From: Simon Davis
Sent: 25 March 2019 16:59
To: Planning.Responses
Subject: FW: Planning Consultation on Y/21/19/DOC
Attachments: 14_16_505 External Wall Details.pdf; Orchard Business Park-SUDs Operations & Maintenance Manual Rev B.pdf

From: kazys [REDACTED]
Sent: 25 March 2019 15:49
To: Laura Gibbons <Laura.Gibbons@arun.gov.uk>
Cc: Paul Spratt [REDACTED] Simon Davis <Simon.Davis@arun.gov.uk>
Subject: Planning Consultation on Y/21/19/DOC

Engineers Comments Regarding Condition 9- surface water drainage design

Comments Regarding Condition 10- SuDS maintenance manual

Typical 575mm (max) high retaining wall section 1:20
(see site plan for locations)

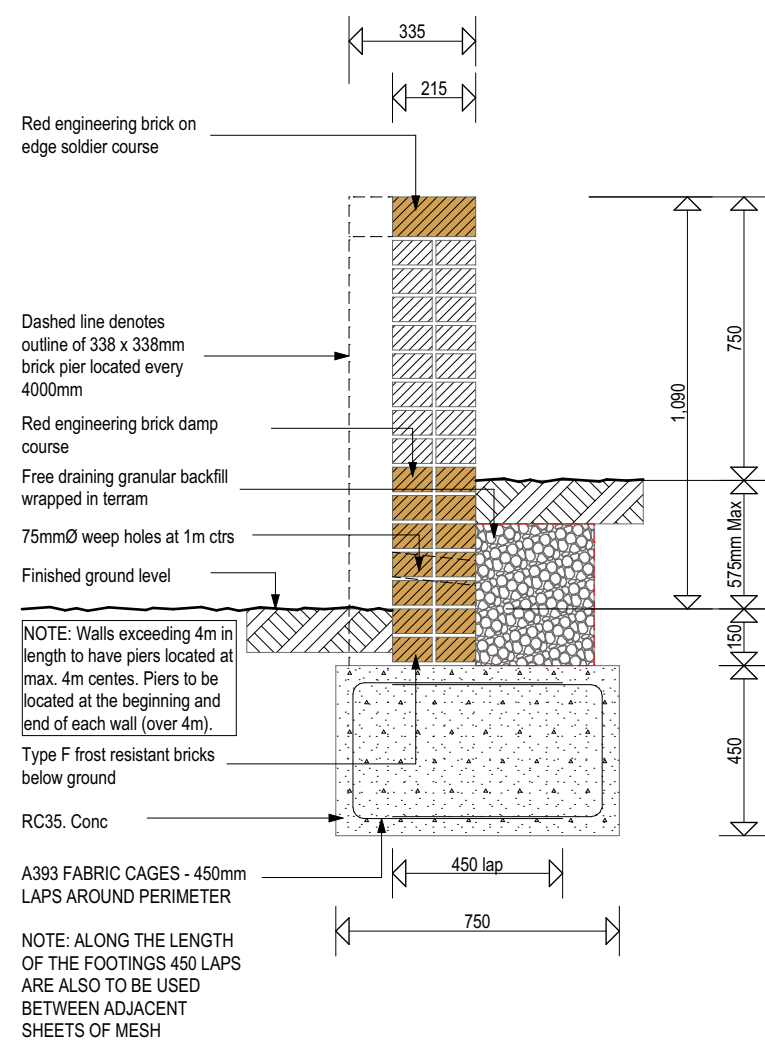
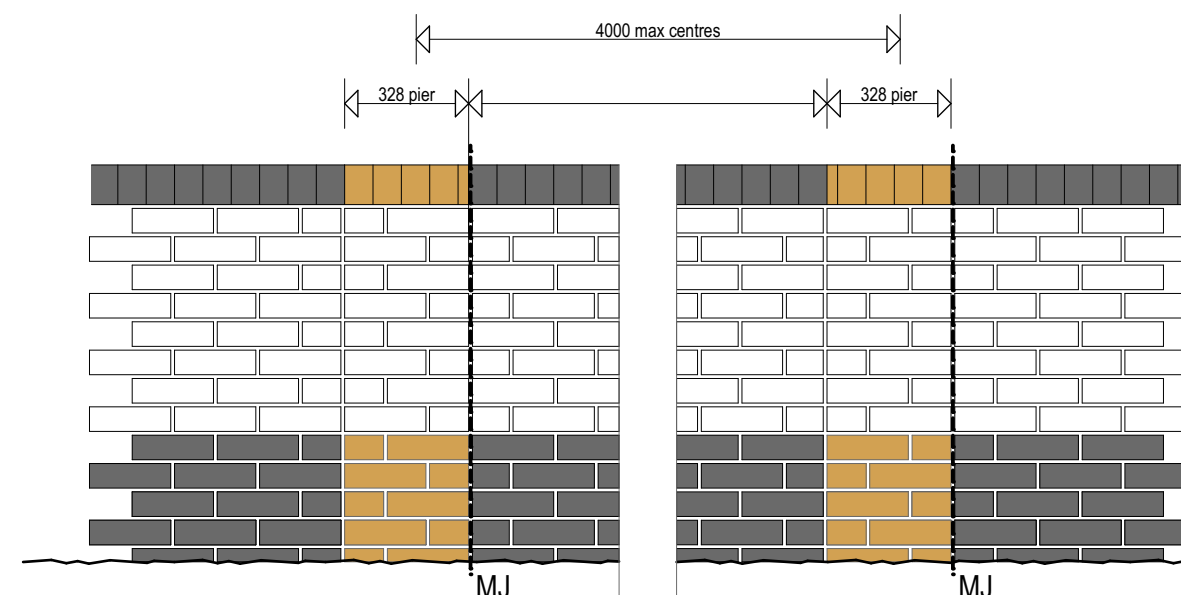
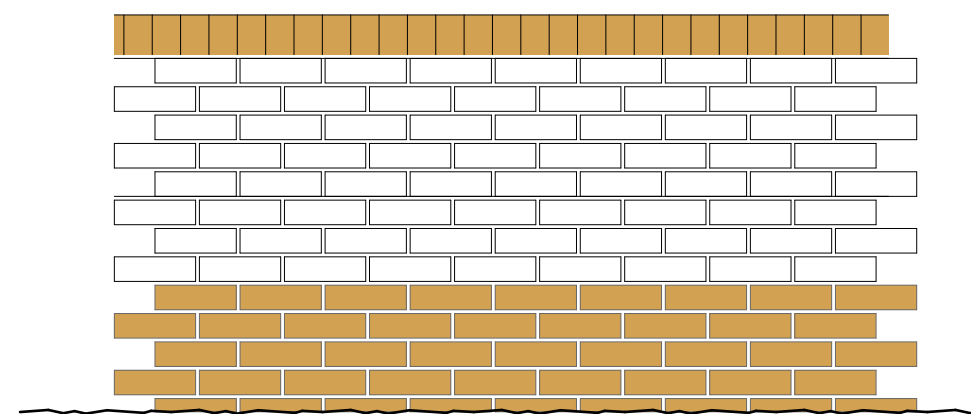
Please provide details of the proposed retaining walls, and in particular the drainage associated with these.

- Please find attached a detail of the proposed retaining wall applicable for the retained height. Regarding the drainage associated with the proposed wall I believe that the construction of the weep holes shown on the detail will adequately cater for any surface water flows that you may have concerns about.
- The SuDS Maintenance Manual has been amended in line with your comments.
